PROJECT NO. 100 2087	APPLICATION NO. 02DAB - 01262
PROJECT NAME La Mesa (20 & 21)	
EPC APPLICATION NO.	
APPLICANT / AGENT Jim Wilks	PHONE NO. 888 - 3066
ZONE ATLAS PAGE K-19	
ONE STOP COMMENT FORM LOG

CITY OF ALBUQUERQUE
 PLANNING DEPARTMENT
 DEVELOPMENT REVIEW BOARD

11. Project #1002087
Application # 02DRB-01062
La Mesa Subdivision, Lots 20-A and 21-A, Block 4

VICINITY MAP No. K-19

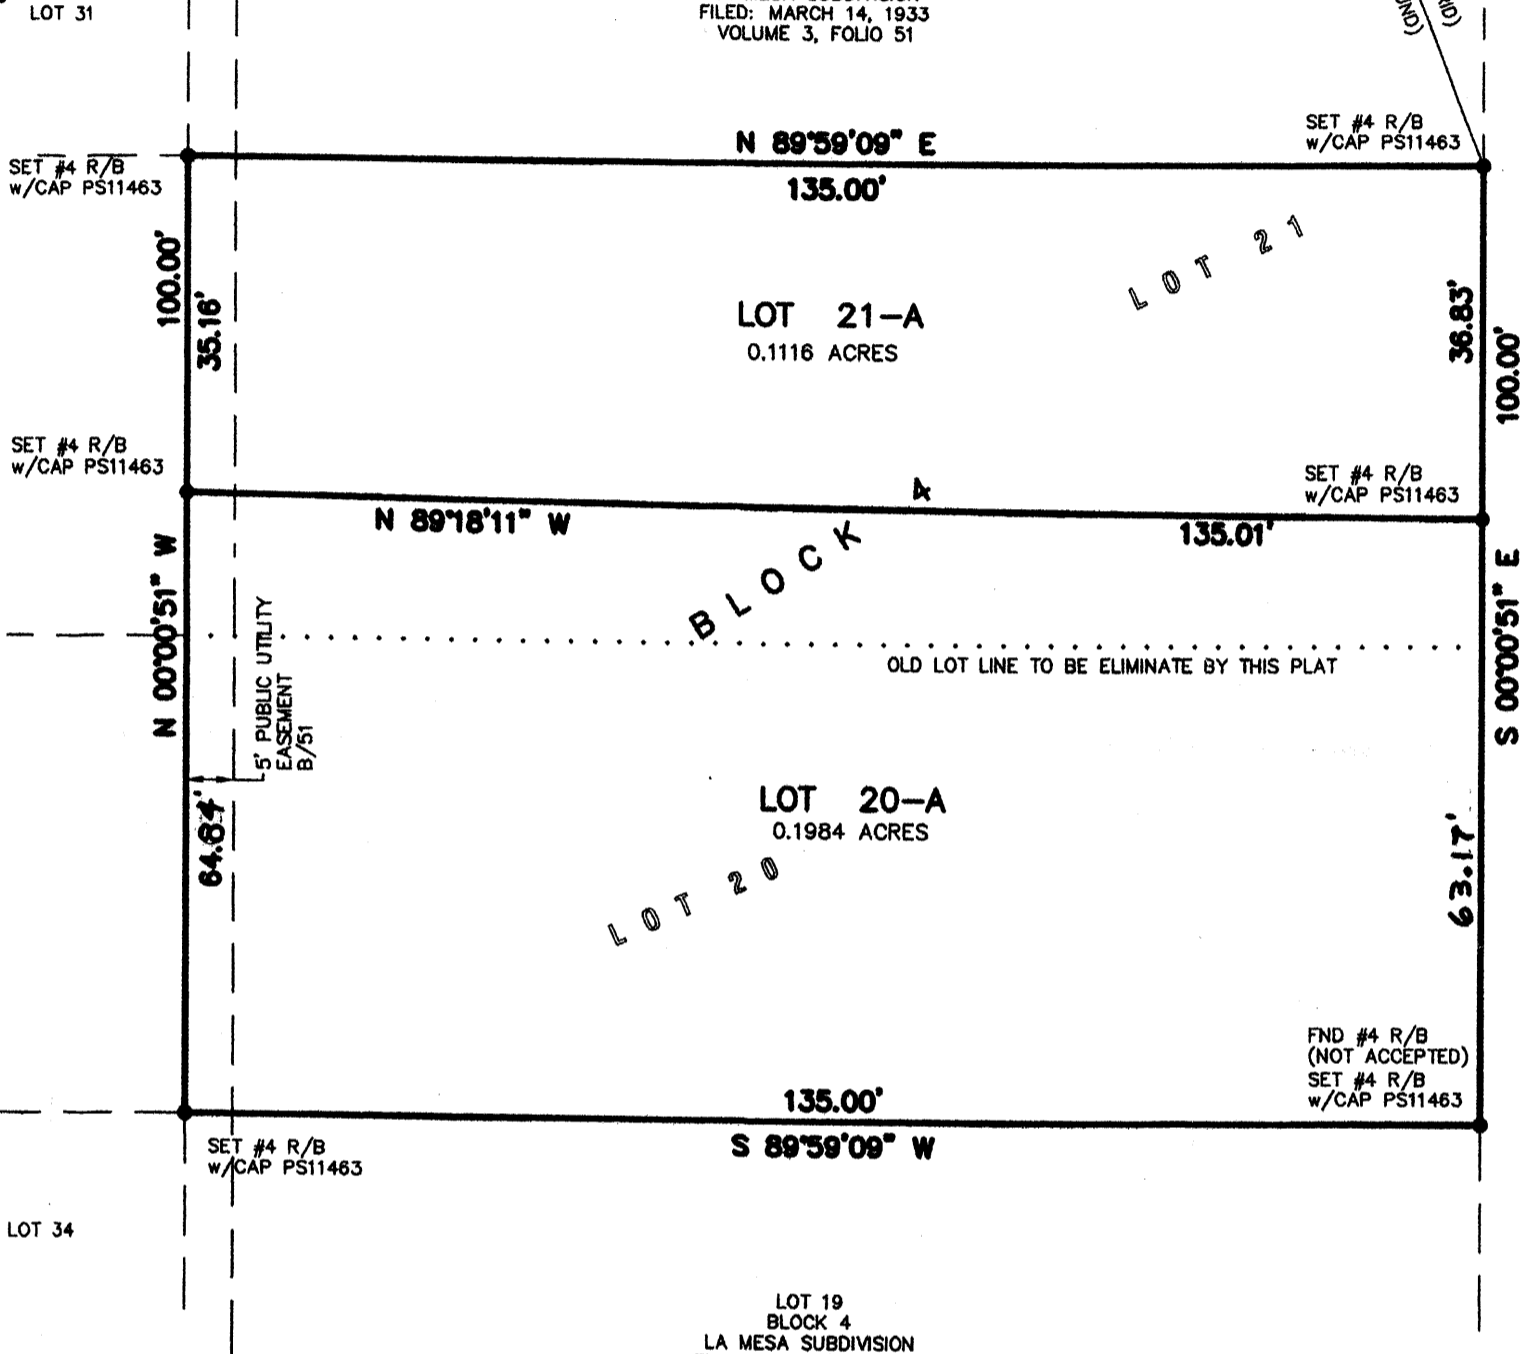
- > 1. The site marked on the Vicinity Map on the plat is incorrect. Please mark the site on Espanola rather than on Utah Street.
- > 2. It appears that the proposed lots will require several setback variances. Contact Tom Rojas, Office of the Zoning Hearing Examiner, at 924-3938 for further information regarding application procedures.

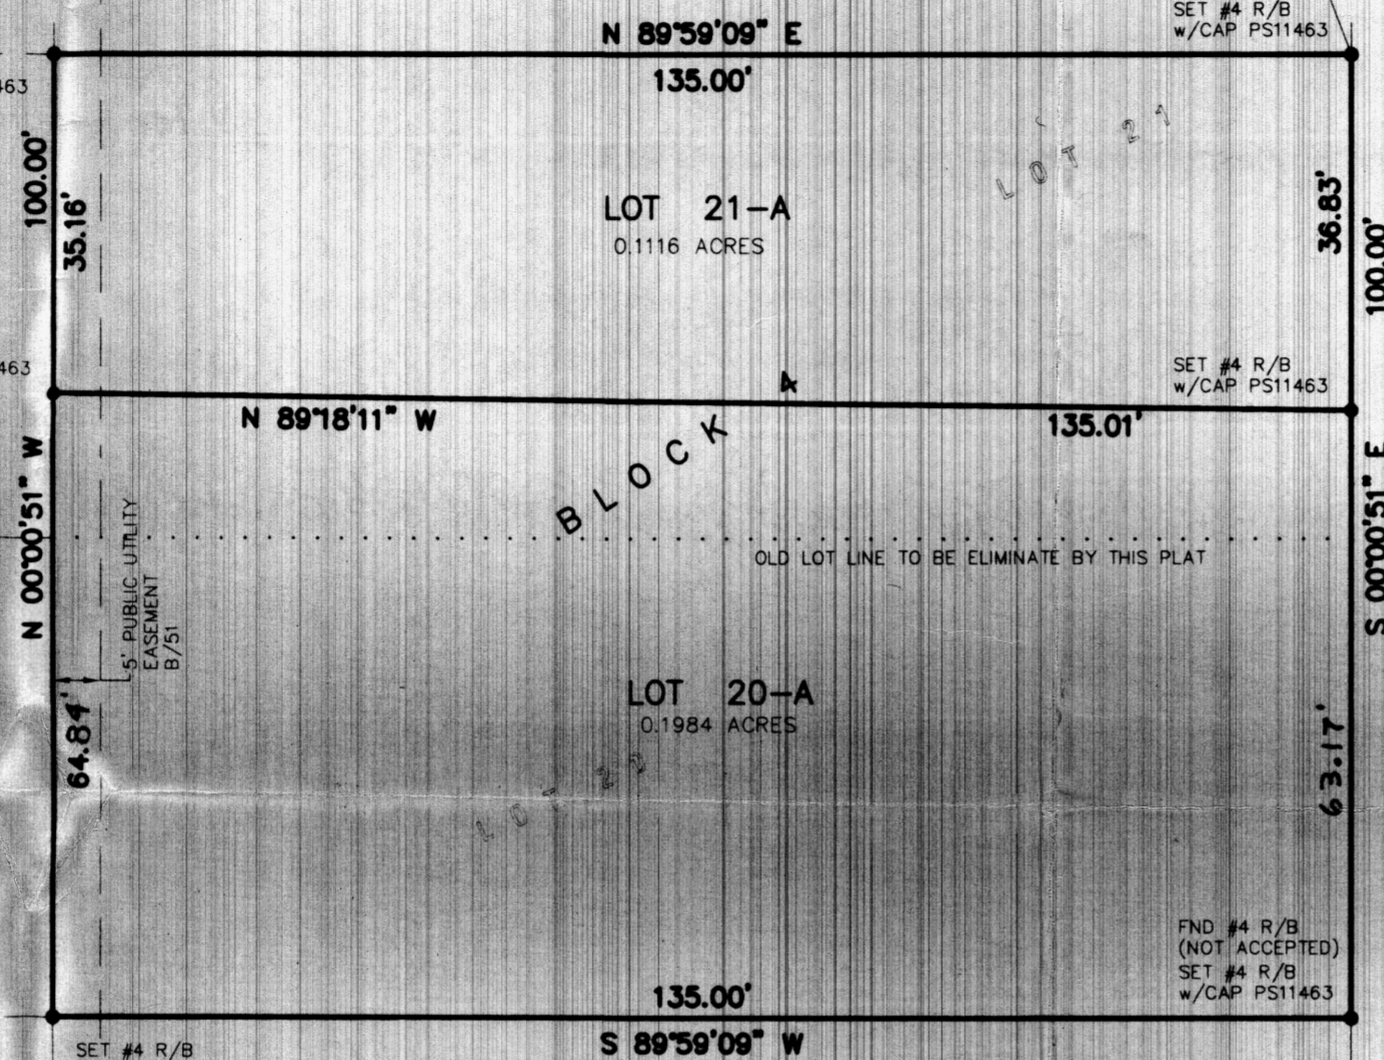
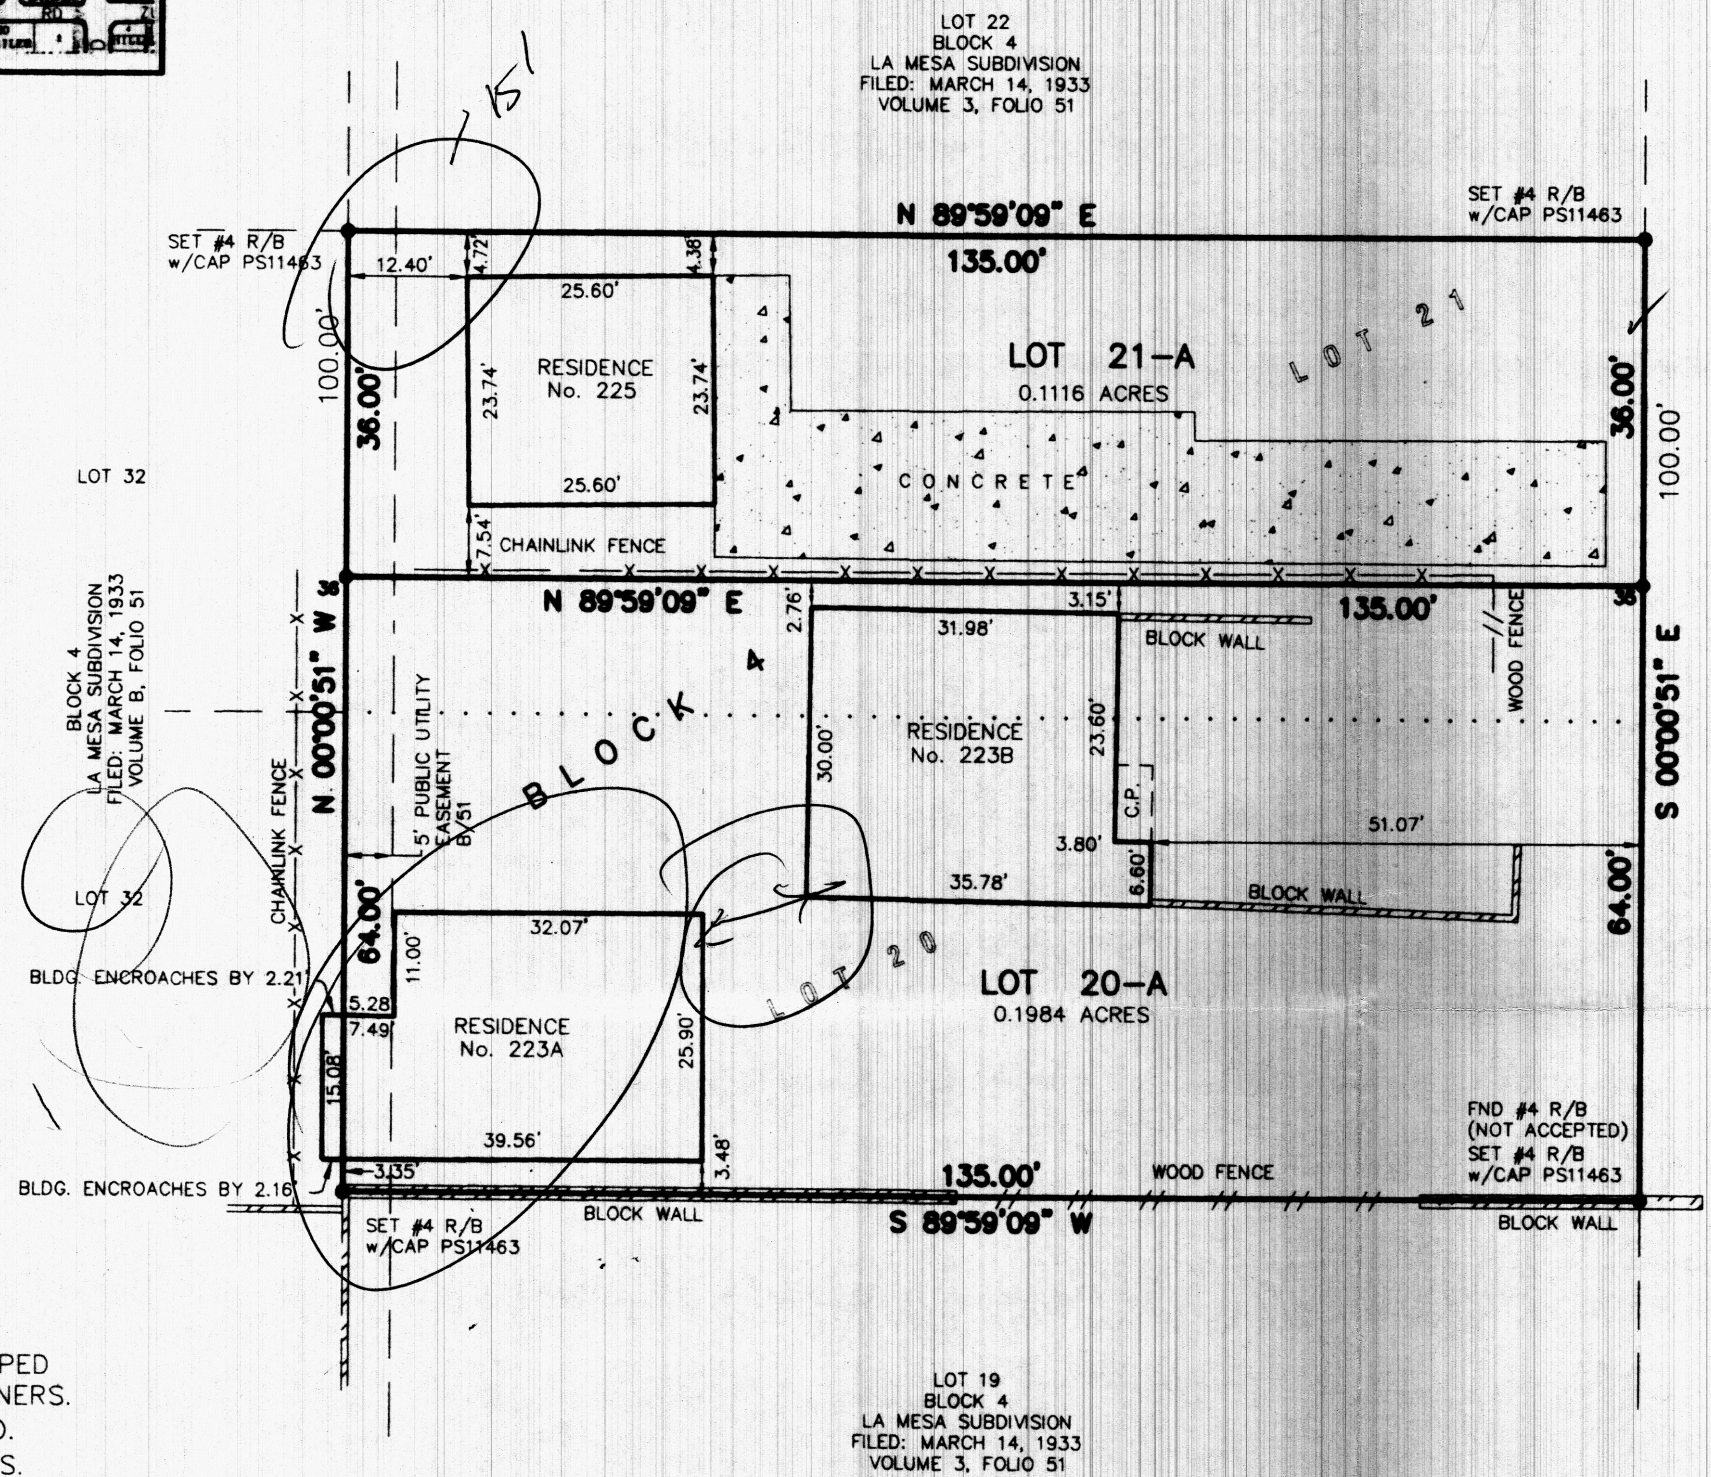
① The comments from Zoning have not been incorporated into the plat. Please address. ② Property Management's signature is not required on this particular plat and may be marked "n/a". ③ Planning signs plat. All other City and utility company signatures must be obtained prior to requesting final sign-off by Planning. ④ Minut plat (if not completing a variation) may be recorded by the applicant/agent. A copy of the recorded plat must be provided to Planning in order to close the lease file. ⑤ Please provide a digital dxf file showing easement, right-of-way (Return form with plat / site plan) and parcel lines in New Mexico State Plane Foot NAD 1927 or 1983 for AGIS purposes. The information may be e-mailed to jmcSorley@cabq.gov or forwarded in a diskette.

- > 3. What is the distance between Residence 223A and 223B? Please add to the plat.
- 4. Residence 223A encroaches into the adjacent lot to the west. How is this being resolved?

1002087 RT ZONE.
 No setback variances
 are necessary - proposed
 replat will affect
 no existing relationships
 of bldg separation.
 Requires min. 36' wide
 lot 21-A, ^{measured} 50' frontfront,

with 3' ^{side} setback to
 forward house lot
 20-A for UBC
 compliance. Suggest
 slight angle front
 to rear for shared
 property line - 36.10'
 front, 35.9' rear length
 due to 20-A - take base.
